M3 Junction 9 Improvement

Scheme Number: TR010055

7.12.7 Statement of Common Ground with Cycle Winchester

31 July 2023

PROJECT STAGE  
**PCF STAGE 3**

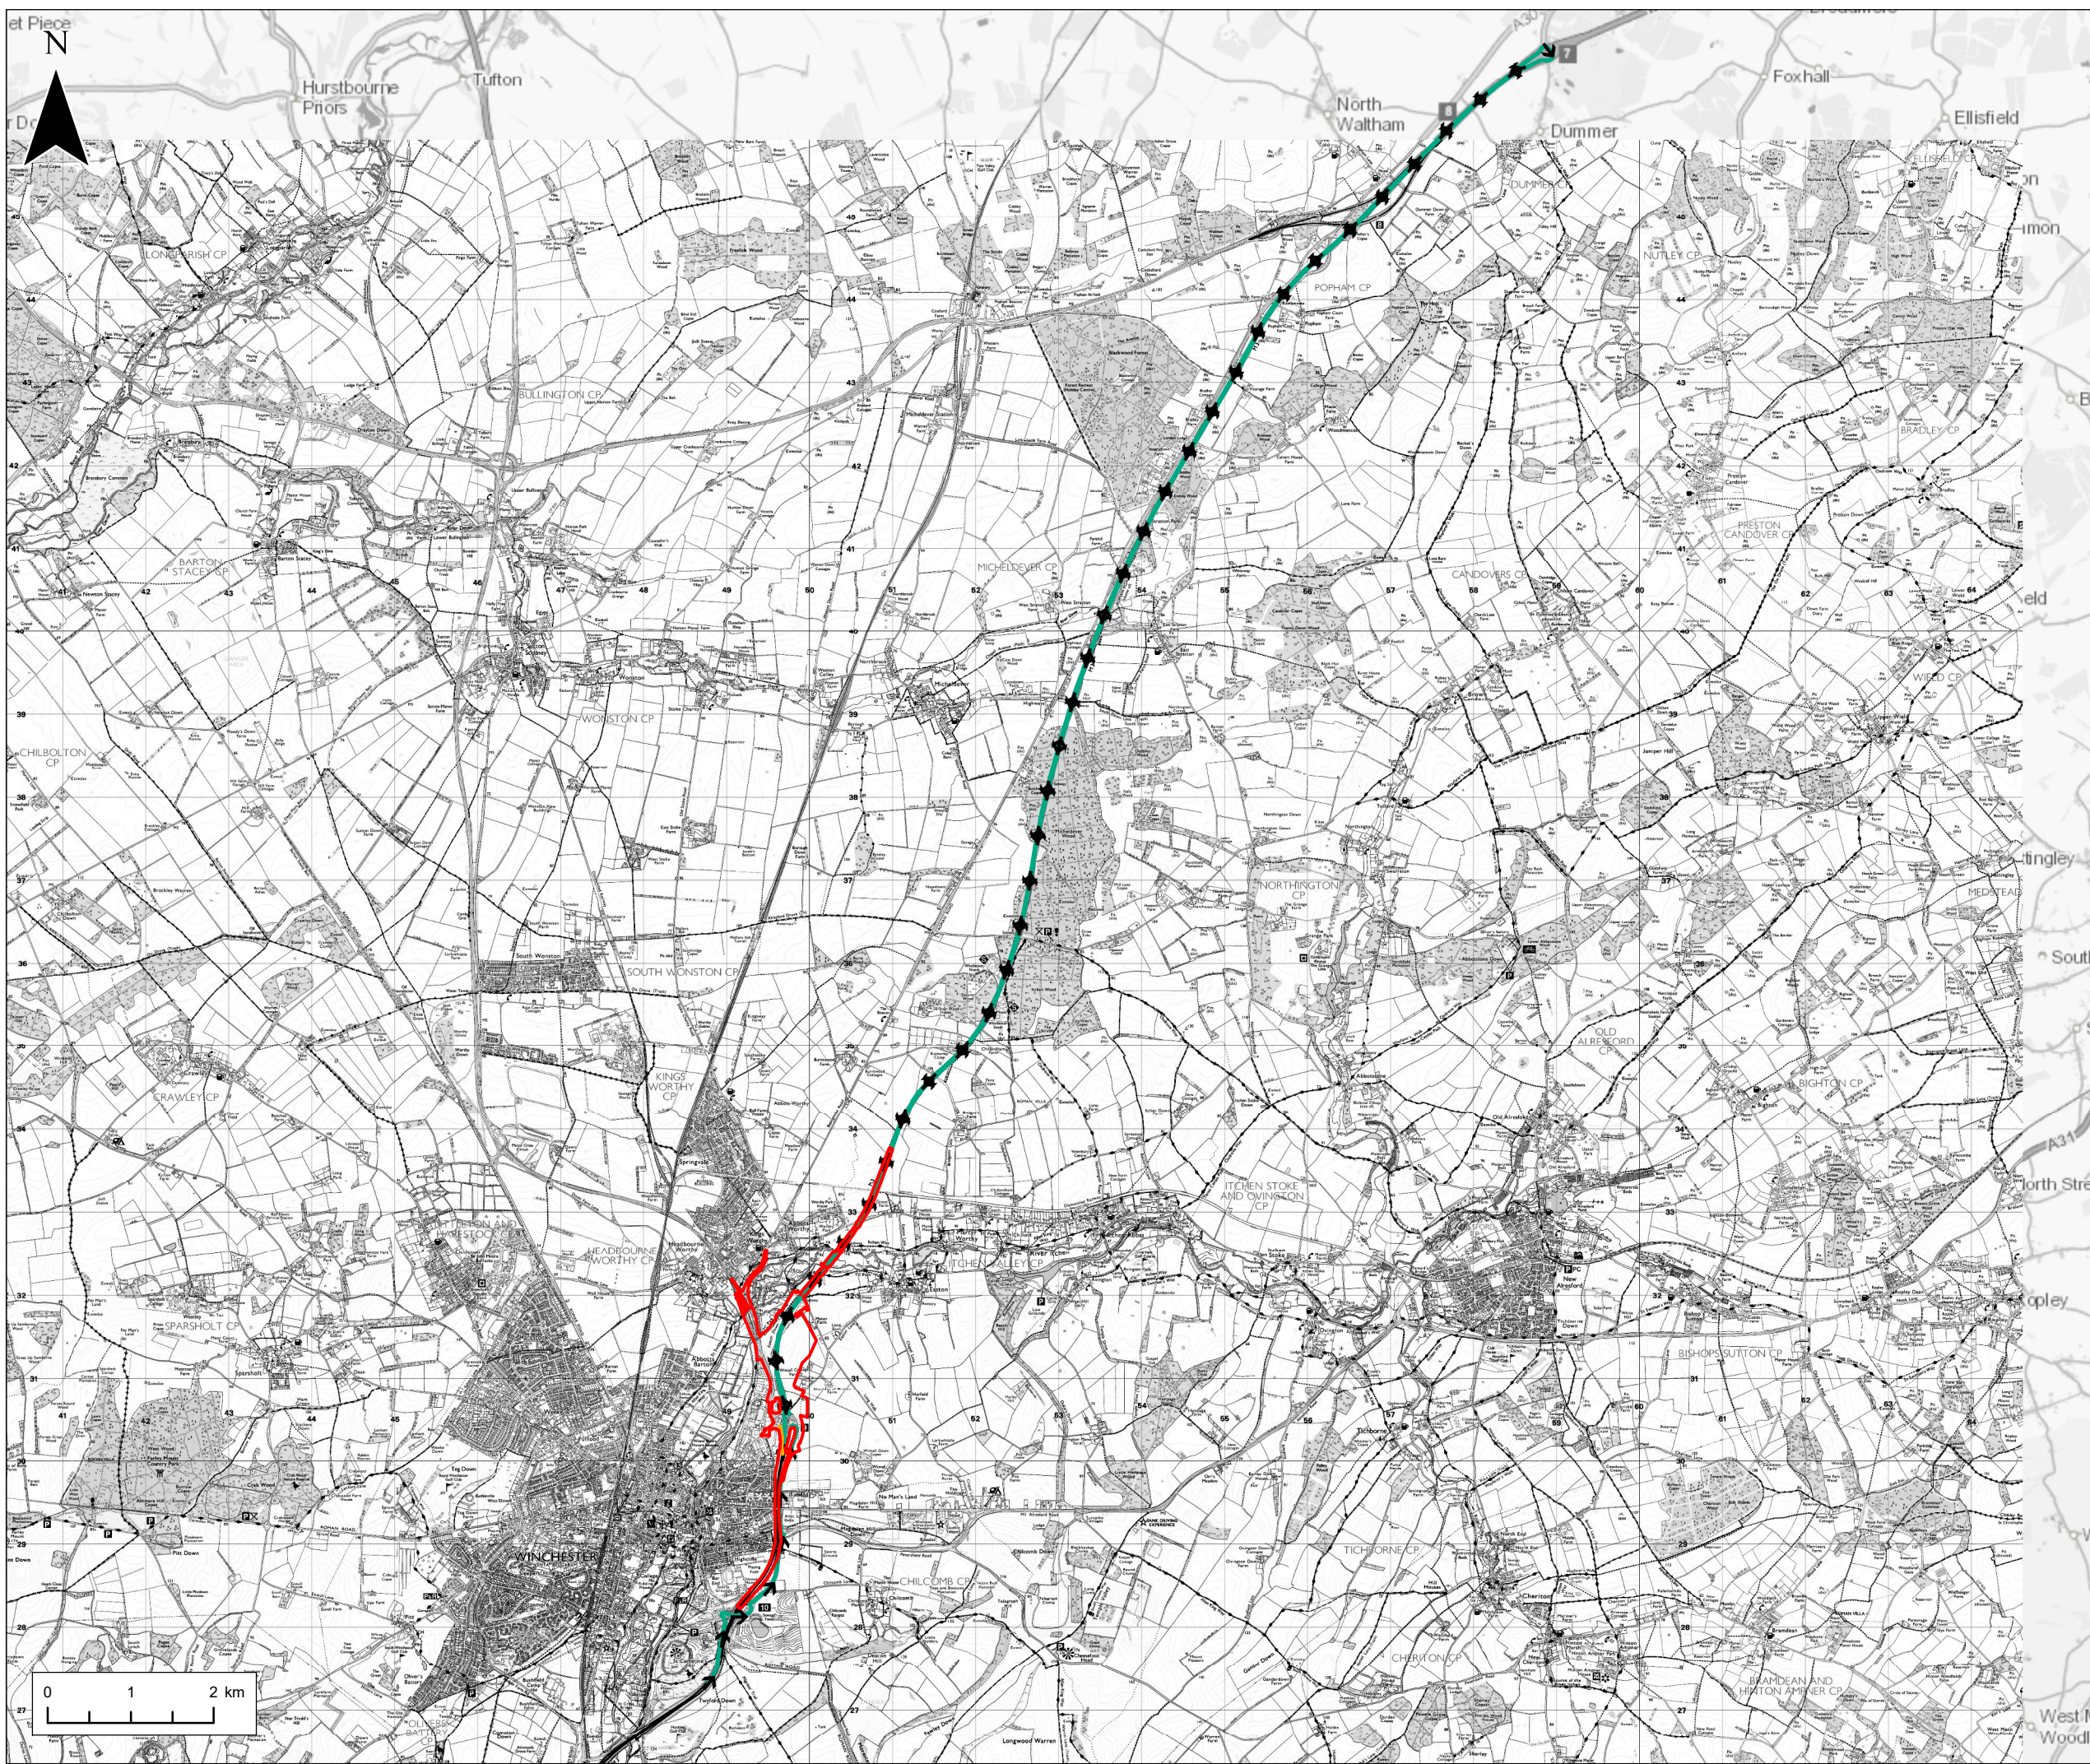
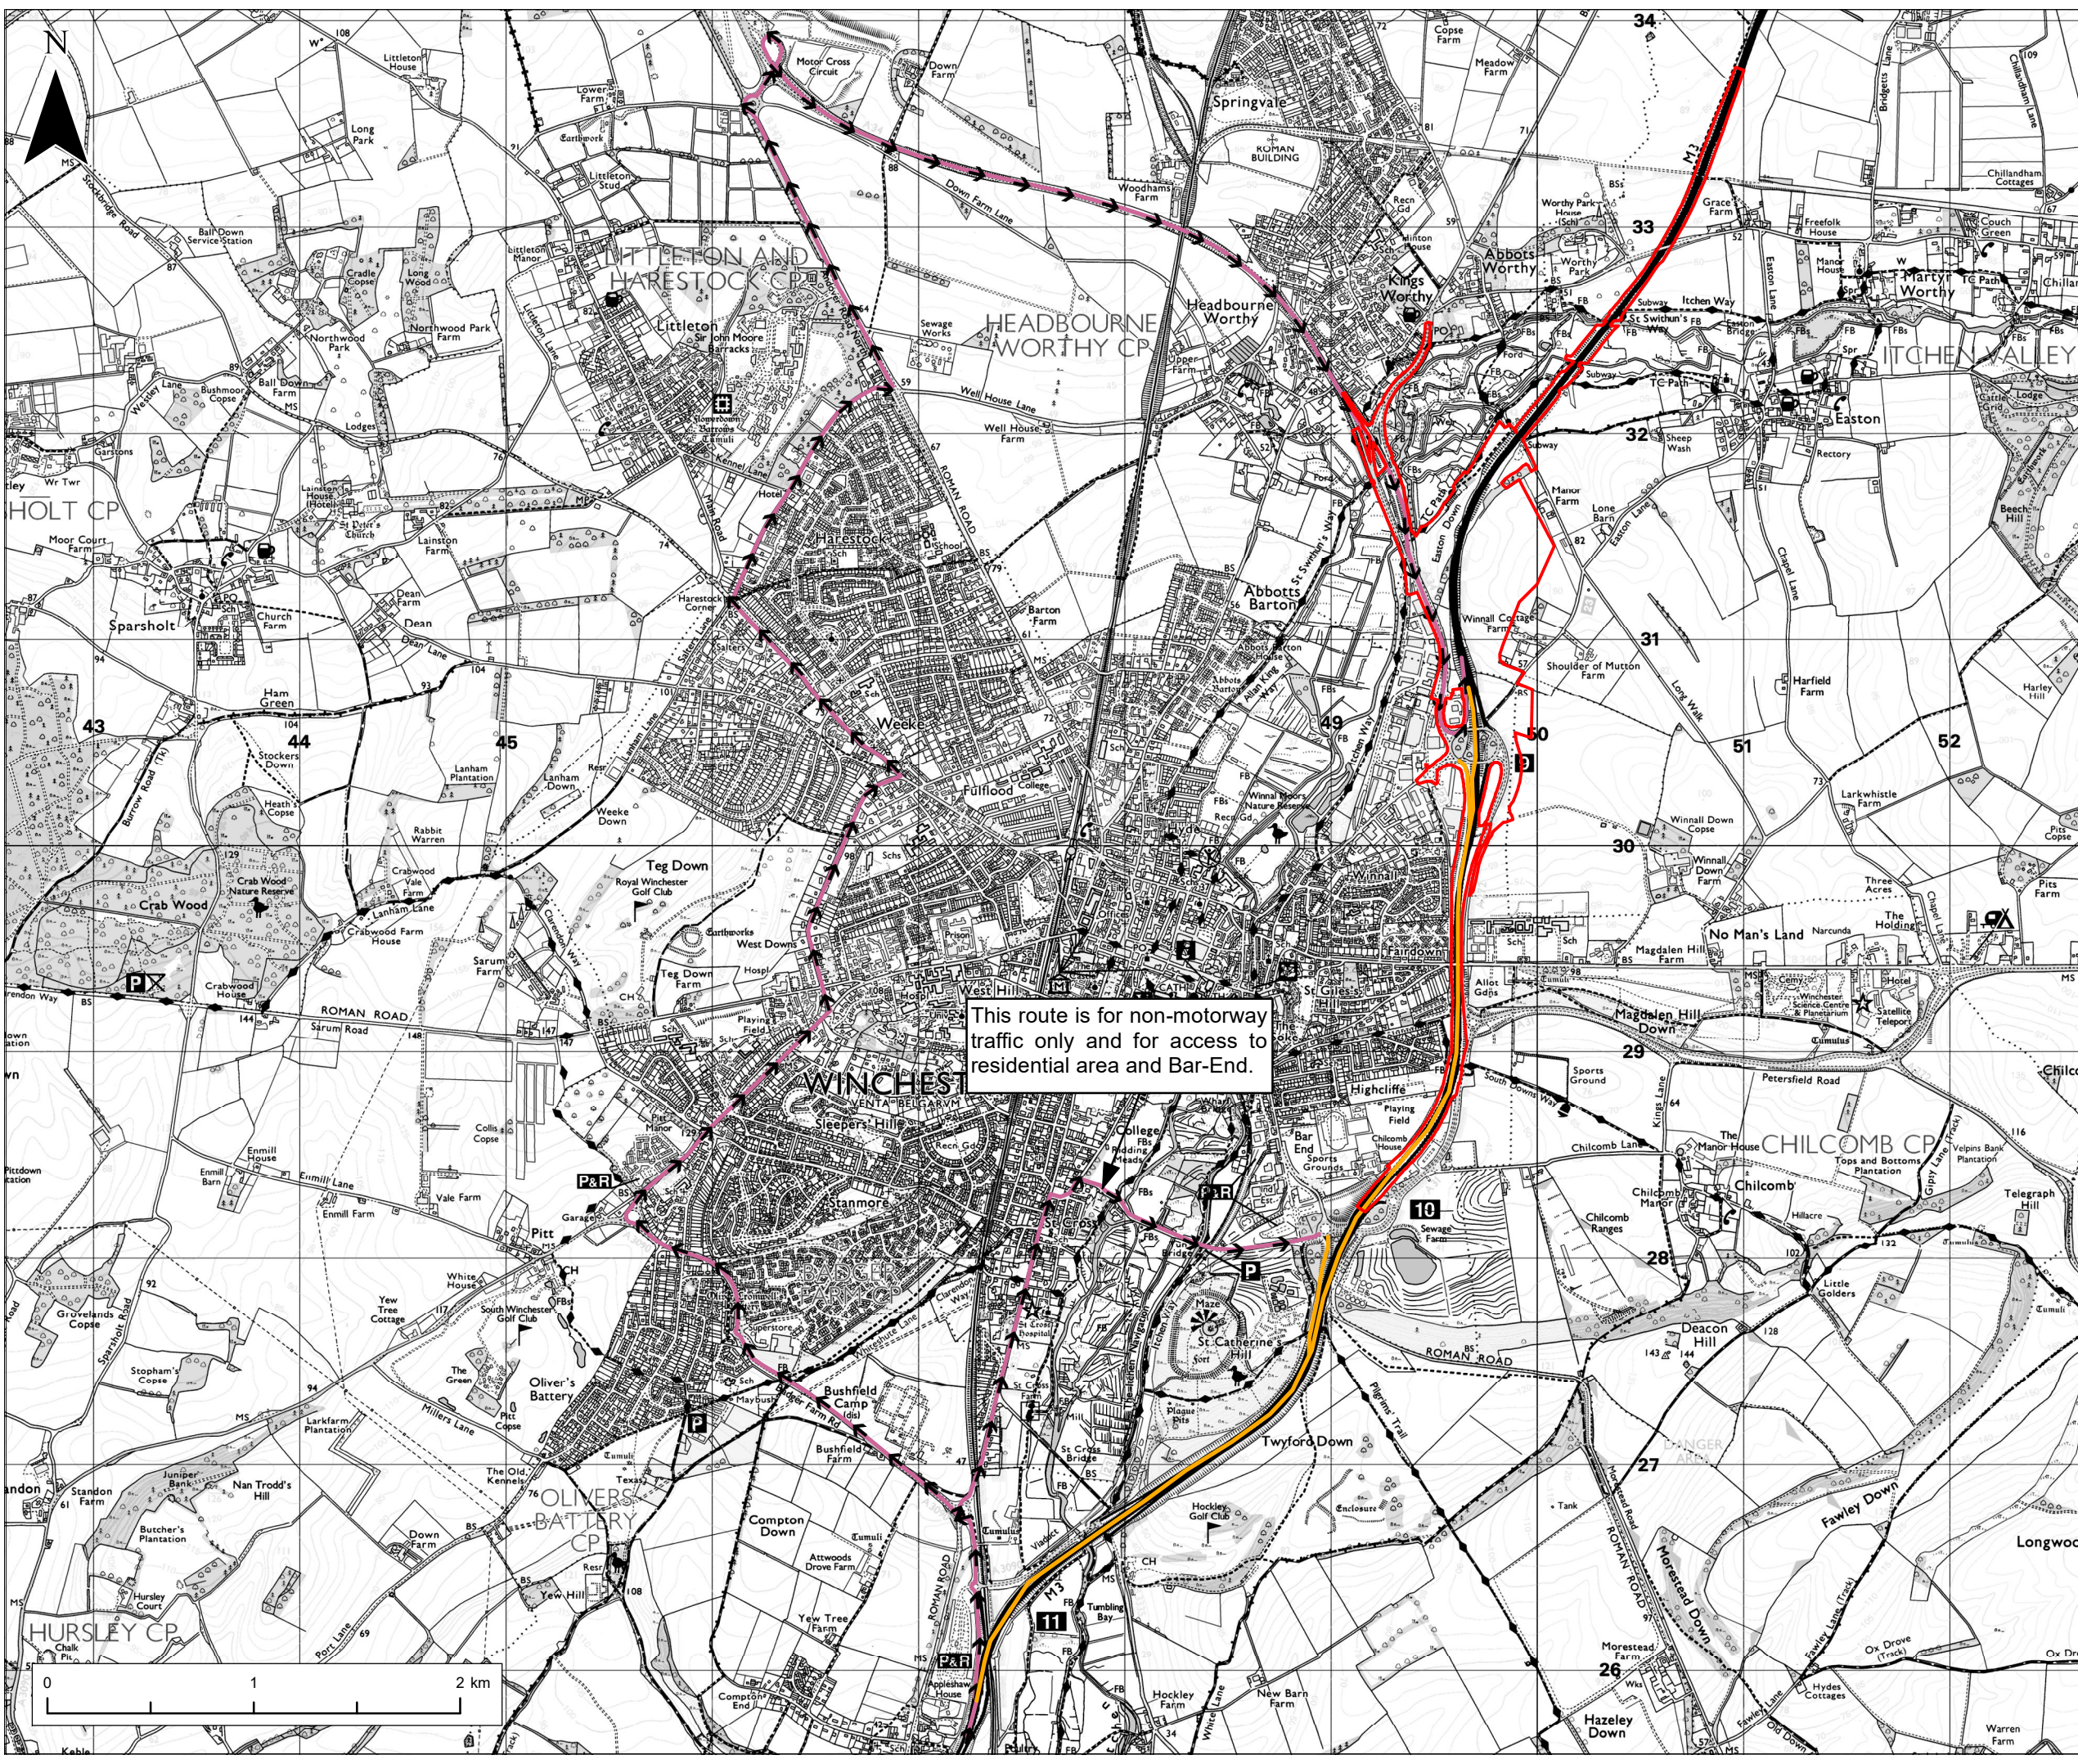
5.2	Diversion routes Impact of traffic diversion on cyclists	Outline Traffic Management Plan (7.8, Rev 1), Figure 2.5 of Chapter 2 (The Scheme and its Surroundings – Figures (Part 3 of 4)) of the ES (6.2, APP-063)	<p>Cycle Winchester has the impression that the project team has not yet considered the impact that traffic diversions during construction will have on cyclists. Examples of areas where the diverted traffic might have an impact on cycling include many of the major routes in and out of Winchester, as a Junction 9 closure or complete M3 closure would force more traffic onto these roads. Some examples:</p> <ul style="list-style-type: none"> ▪ B3047 Worthy Road/Martyr Worthy Road ▪ B3335 St Cross Rd and Twyford Road ▪ B3420 Andover Road ▪ B3330 Bar End Road ▪ Minor roads, especially in the upper Itchen valley east of the junction <p>Again, we would like to see a clear consultation process that will ensure that consultation happens, that the effects on non-motorised road users are accounted for, and appropriate measures are taken.</p>	<p>Diversion routes via the B3047, the B3420 Andover Road and road east of the junction (A31) will be implemented at various stages of the Scheme. The works are planned to be undertaken during overnight off-peak closures (when there is less traffic on the network) and several extended weekend closures.</p> <p>The B3335 St Cross and Twyford Road and B3330 Bar End Road have been referenced as secondary diversion routes and should only be used by non-motorway traffic, or for those accessing the residential area at Bar-End.</p> <p>There are mitigation measures for rat-running and this will be monitored throughout construction of the Scheme.</p>	Agreed	6 July 2023
